RECOMMENDATION FOR PLANNING AND DEVELOPMENT COMMITTEE

APPLICATION REF: 3/2025/0945

PROPOSED SINGLE STOREY SIDE AND REAR EXTENSION AT 4A WISWELL LANE,
WHALLEY, BB7 9AF

7302 - P01 REV C

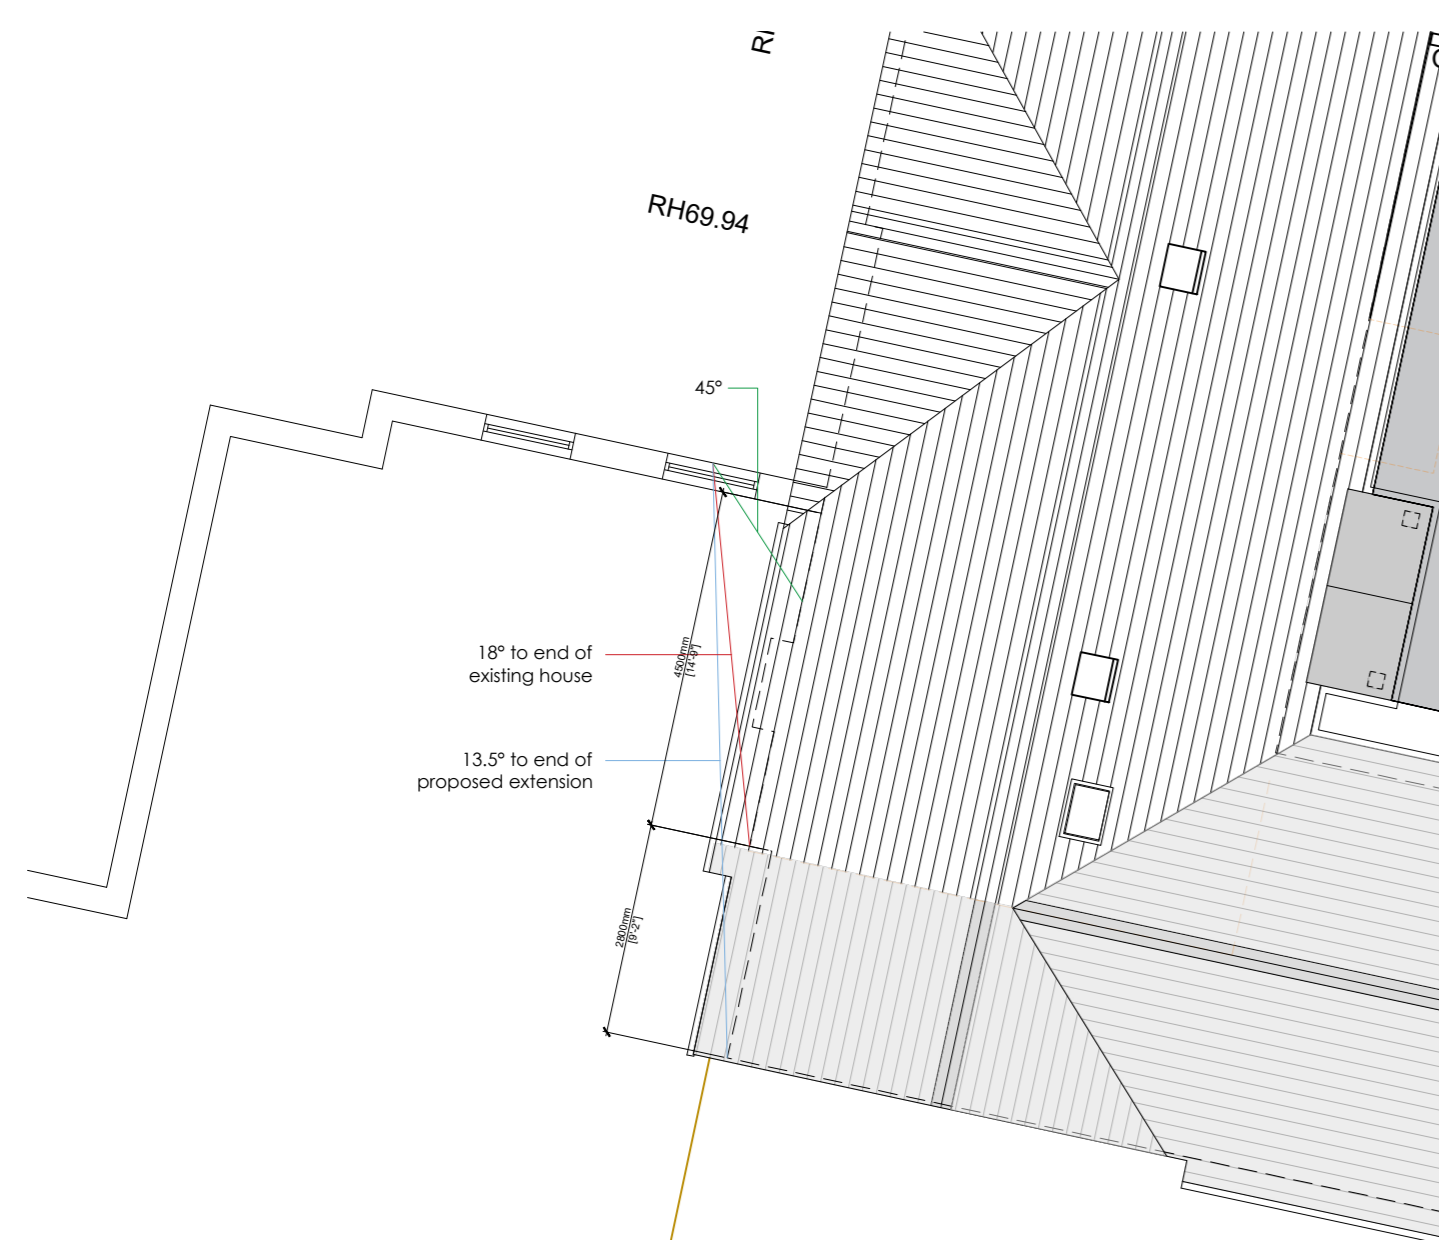
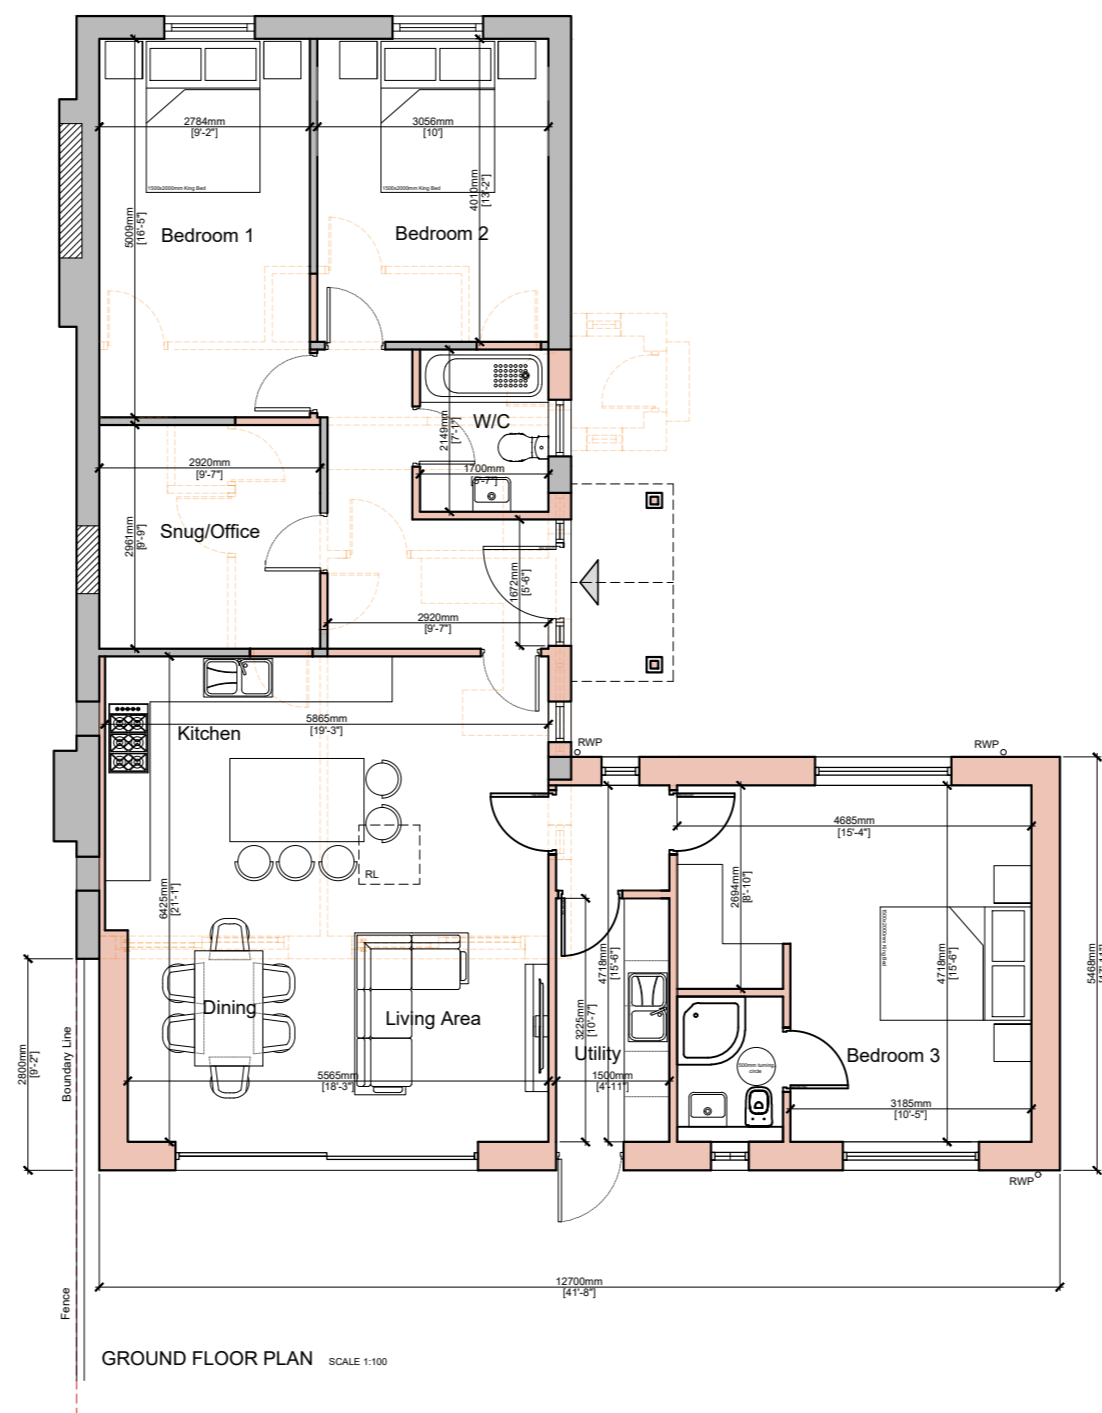
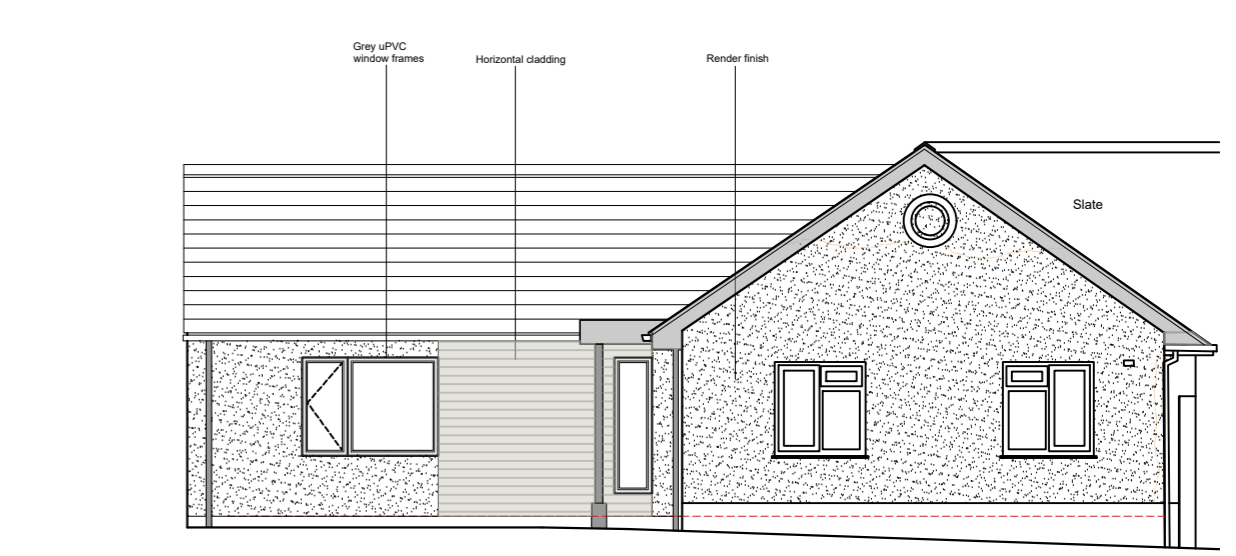
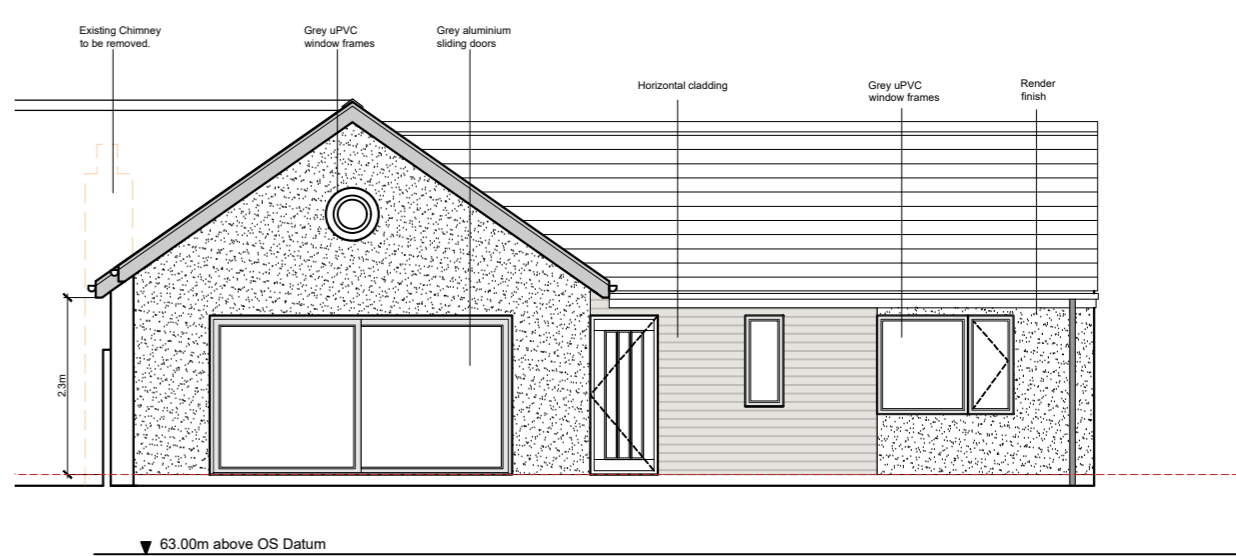
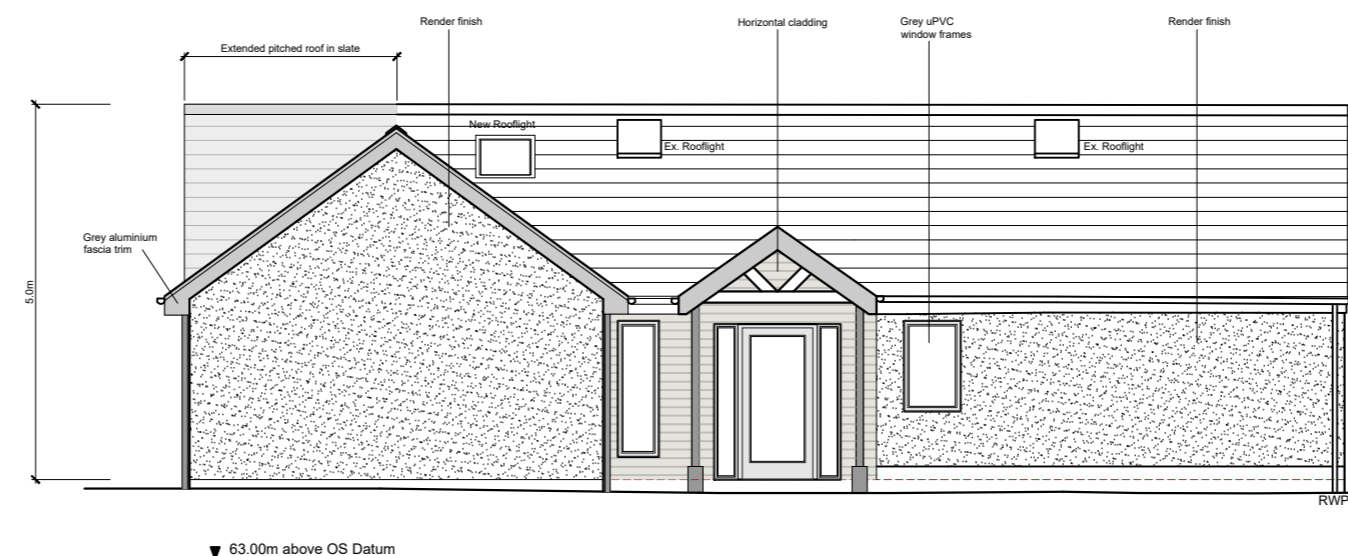
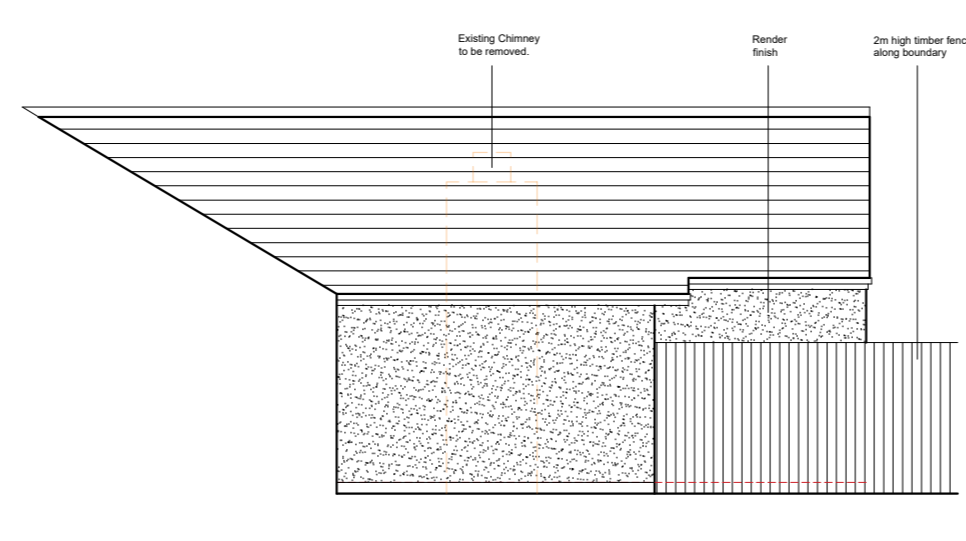
- 5.2.4 Following discussions with the Agent, the extension has been marginally stepped in from the shared boundary in an attempt to mitigate any resultant impact upon the occupiers of No.4 Wiswell Lane. Whilst a greater offset had been requested, it is acknowledged that the existing built form of the application property is already in breach of a 45-degree line drawn from the centre of the neighbouring window, thus likely already resulting in some loss of light. With this in mind, although the development would still likely result in additional overshadowing and loss of light to No.4 Wiswell Lane, on balance, it is not considered that this would warrant the refusal to grant planning permission for this reason alone.

- 5.3.2 Following discussions with the Agent, the scheme has been amended. The sideward projection of the extension has been reduced to 6.5m, and the previously proposed flat roof has been replaced by a pitched roof. The extent of cladding has also been reduced through the incorporation of render to match the main dwellinghouse.

- 5.3.3 Whilst the development would still comprise a substantial footprint, these amendments have improved the visual relationship between the proposed extension and existing built form of the property and are, on balance, considered adequate to address the aforementioned concerns, particularly given the extension would also be considerably set back from the principal elevation.

- 5.3.4 Notwithstanding the above, it is noted that precise details of the proposed horizontal cladding have not been provided as part of this application. As such, a condition can be attached to any subsequent approval requiring these details to be submitted and approved by the Local Planning Authority prior to its use in order to ensure that the cladding is appropriate to the locality.

5.5.1 No alterations are proposed to the existing site access or vehicle parking arrangements. The submitted plans show that two on-site parking spaces can be accommodated to the front of the proposed extension on the existing hard surfaced driveway. This is considered acceptable to meet parking standards for a three-bedroom dwellinghouse and therefore no concerns are raised with respect to highway safety and parking. Additionally the proposed extension would not compromise the access arrangements for the adjacent site (4B Wiswell Lane) or for the adjacent dwelling the subject of the ongoing appeal.

Site Location Plan (1:1250)
Proposed Site Plans, Plans and Elevations (dwg no. 7302 – P01 Rev C)

4. Notwithstanding the submitted details, precise details of the proposed horizontal cladding shall have been submitted to and approved in writing by the Local Planning Authority before its use in the proposed development. The development shall be carried out in strict accordance with the approved details.
